**Redevelopment of Harbourside Shopping Centre, Darling Harbour
Response to Submissions (SSD 7874)**

Thank you for your correspondence via Major Projects Portal on 1 April 2020, requesting Transport for NSW (TfNSW) to comment on the above.

Image 114 Basement access, and Darling Drive drop off locations

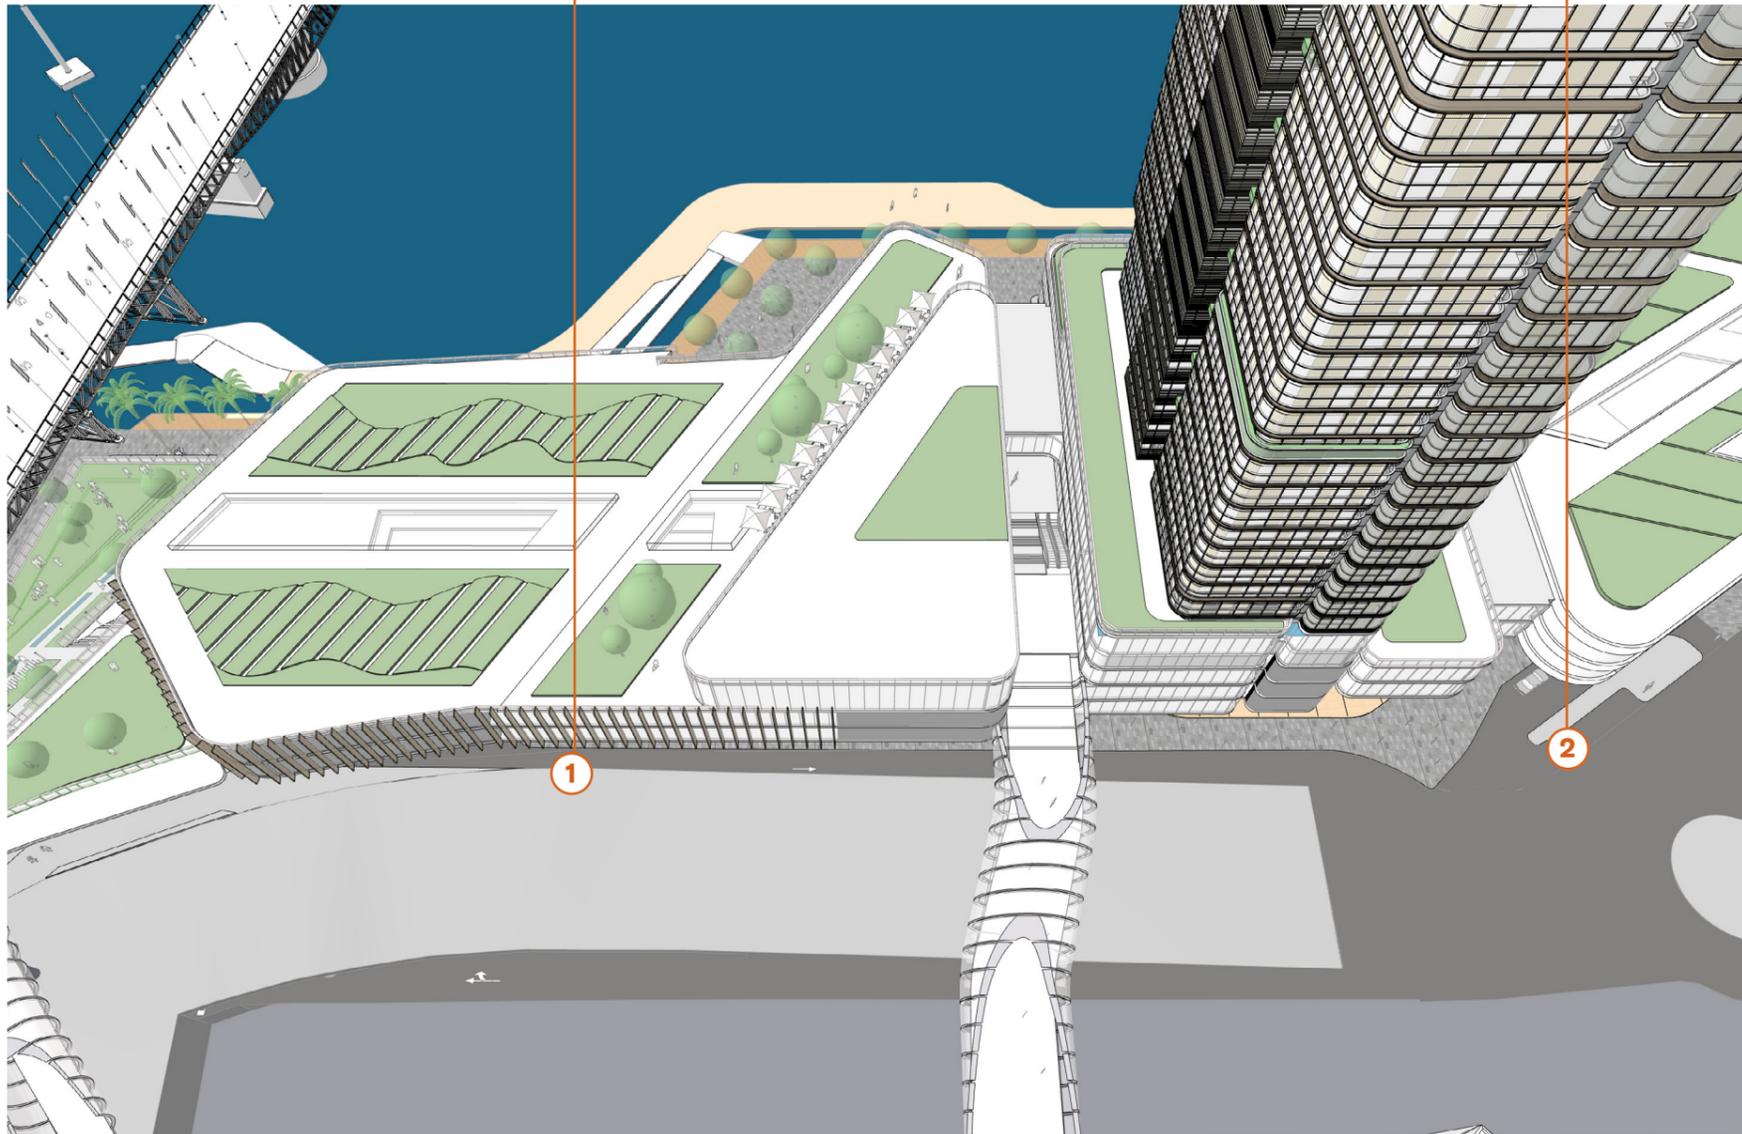
It is advised that the vehicles queuing to access this drop off zone may cause delays and block vehicles on Darling Drive. In addition, any queuing due to vehicles accessing the car park and loading and servicing area may also cause delays and block vehicles on Darling Drive.

- *Queuing analysis and/ or traffic modelling to demonstrate the drop off area has adequate capacity and propose mitigation measures to ensure queuing on Darling Drive does not occur, to the satisfaction of TfNSW; and*
- *Prepare a draft drop off zone management plan to manage vehicles accessing the site and a draft car park and loading dock management plan.*
